**RE: Planning Application AB/115/14/OUT**

I am writing to object to the outline application for 2 semi-detached houses to be built in the front gardens of 12 and 14 Canada Road, Arundel. As an immediate neighbour I am very concerned that the proposed development will have a serious impact on the standard of living for owners of the adjoining properties.

Drg Title: SITE PLAN		Drg No: 14/1950/S01
Client:	Location:	Rev: A
MR SCODFREY	12-14 CANADA ROAD	Scale: 1:200 (A3)
	ARUNDEL	Drawn by: JSW

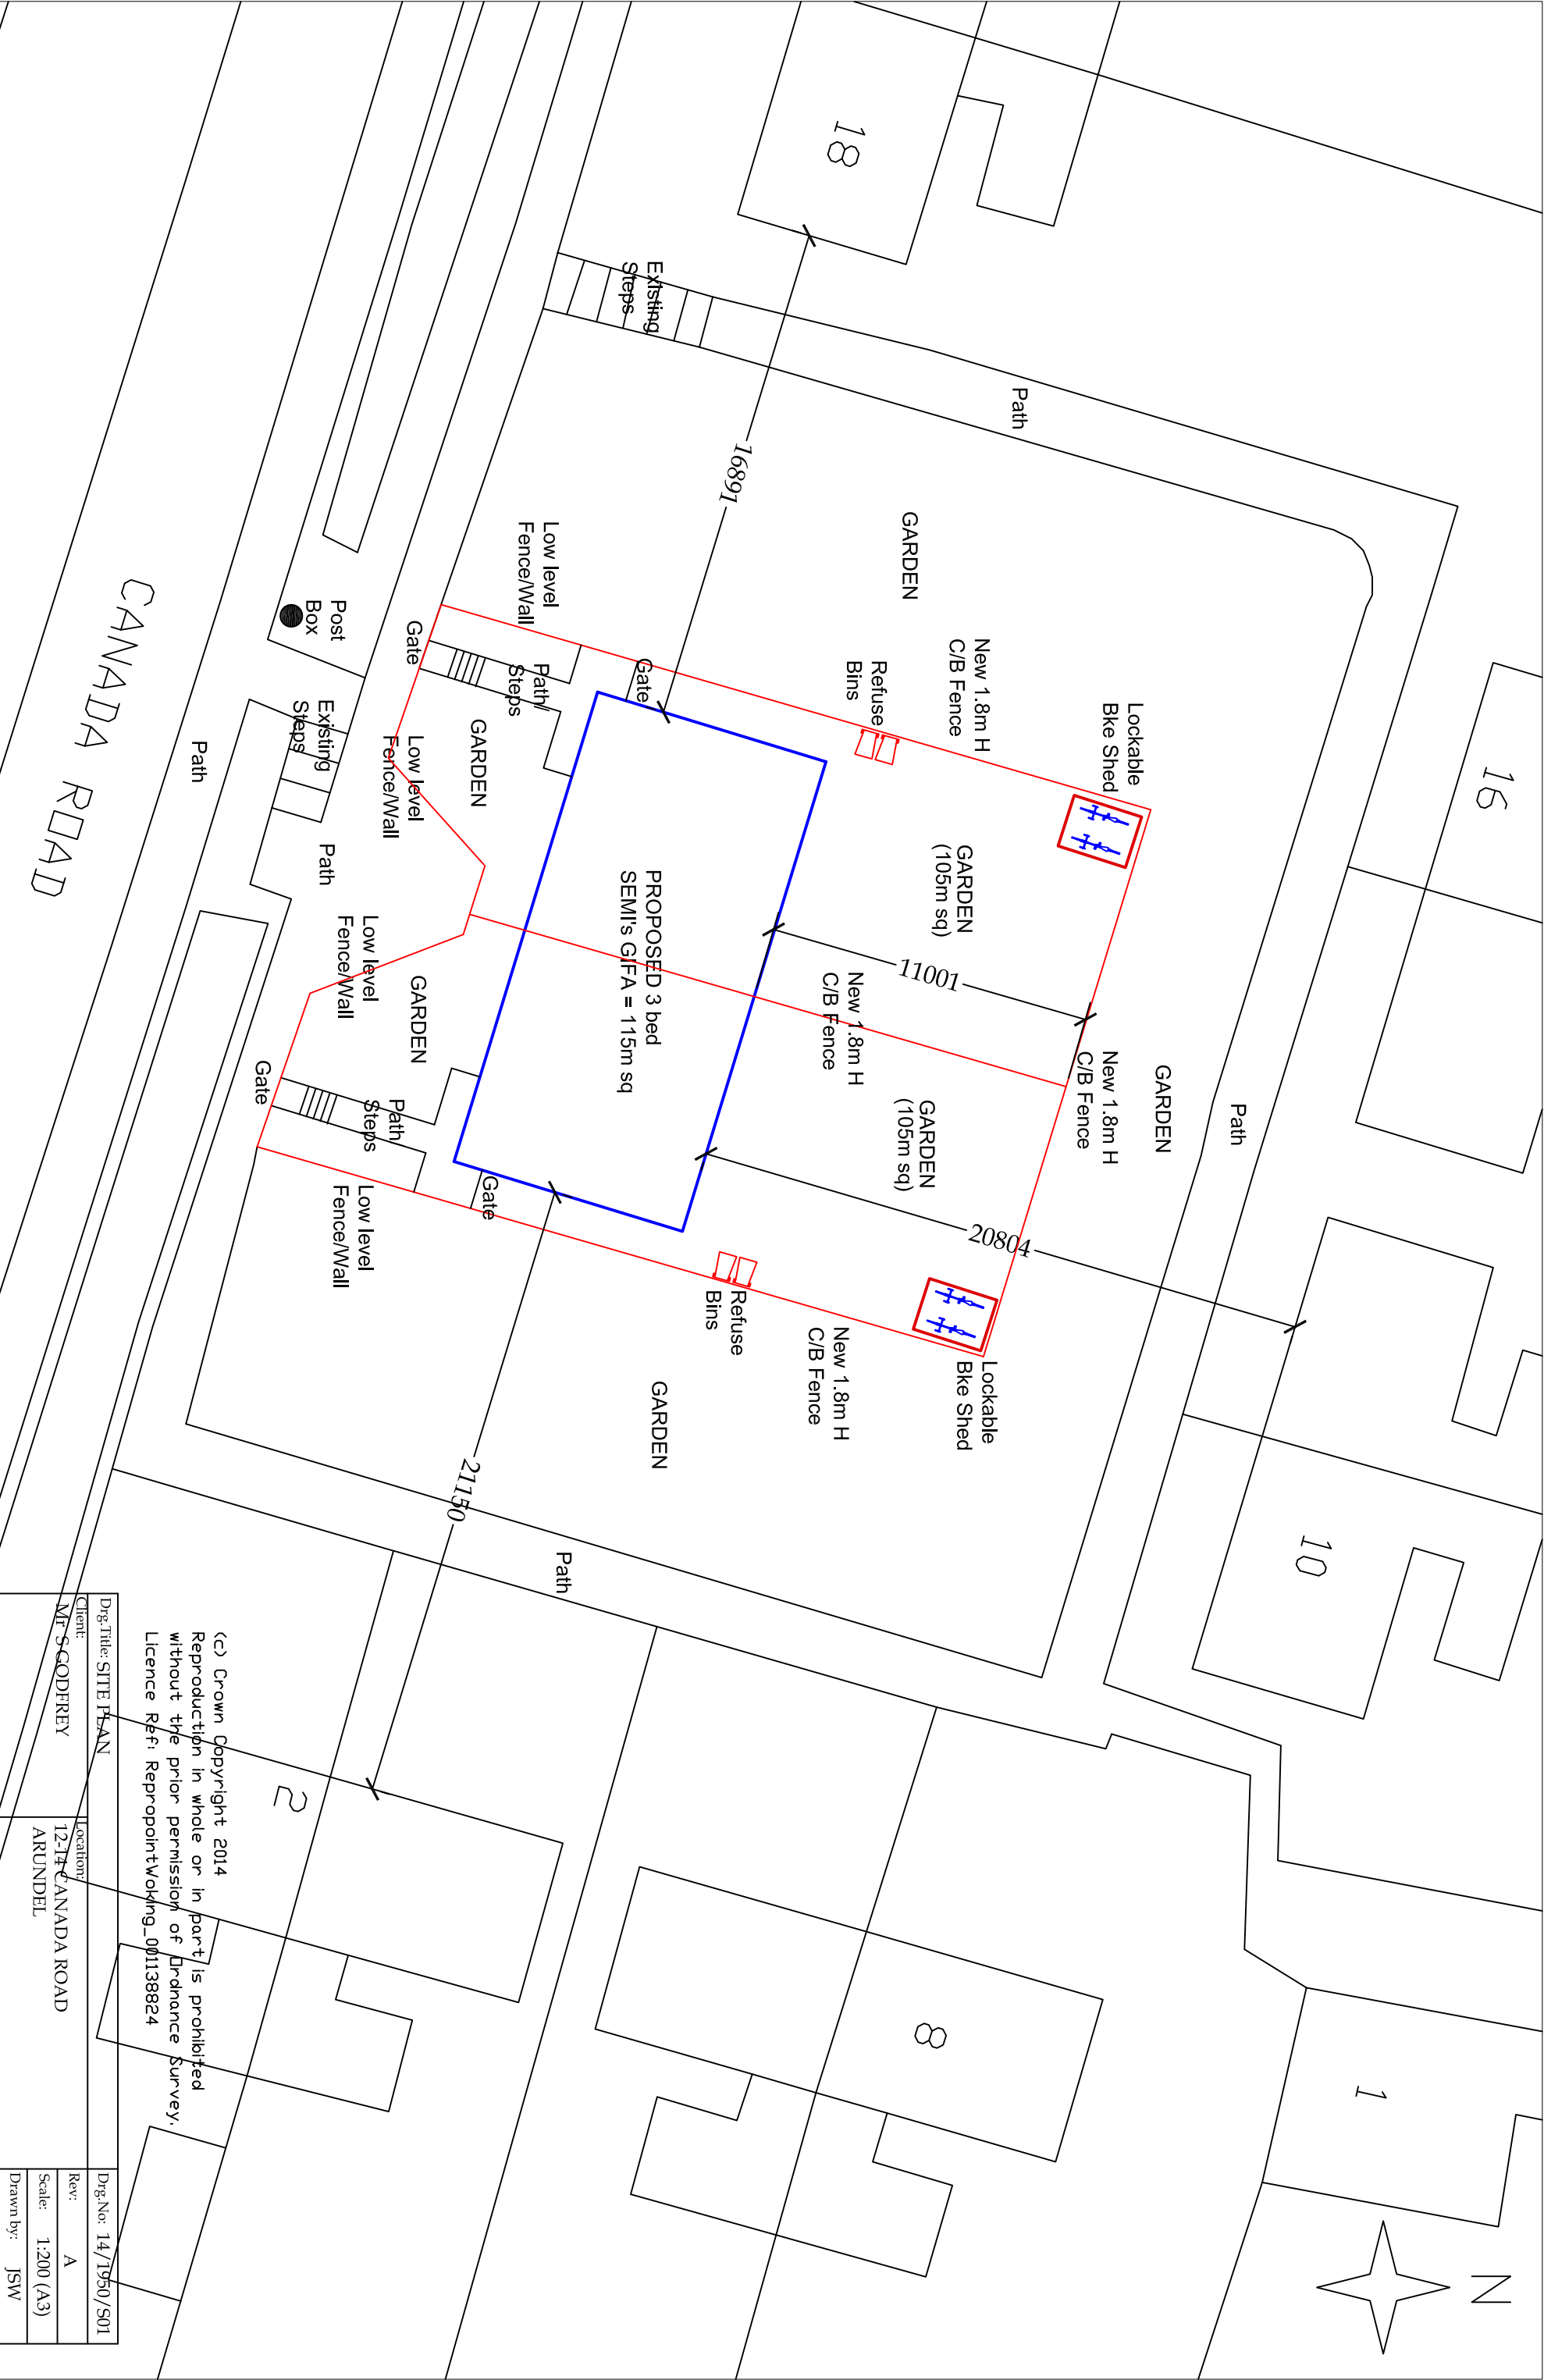
On the plan, the proposed houses appear larger in plan than the existing houses. In particular, the width of the building would seem to be significantly wider and this design would be out of keeping with the surrounding properties.

I am concerned that the proposed development removes the centre path and makes no provision for access to number 12 and 14 should the residents of number 10 and 16 block the path between the respective houses. This could lead to unwelcomed disputes in the future unless access rights are firmly established as part of this application.
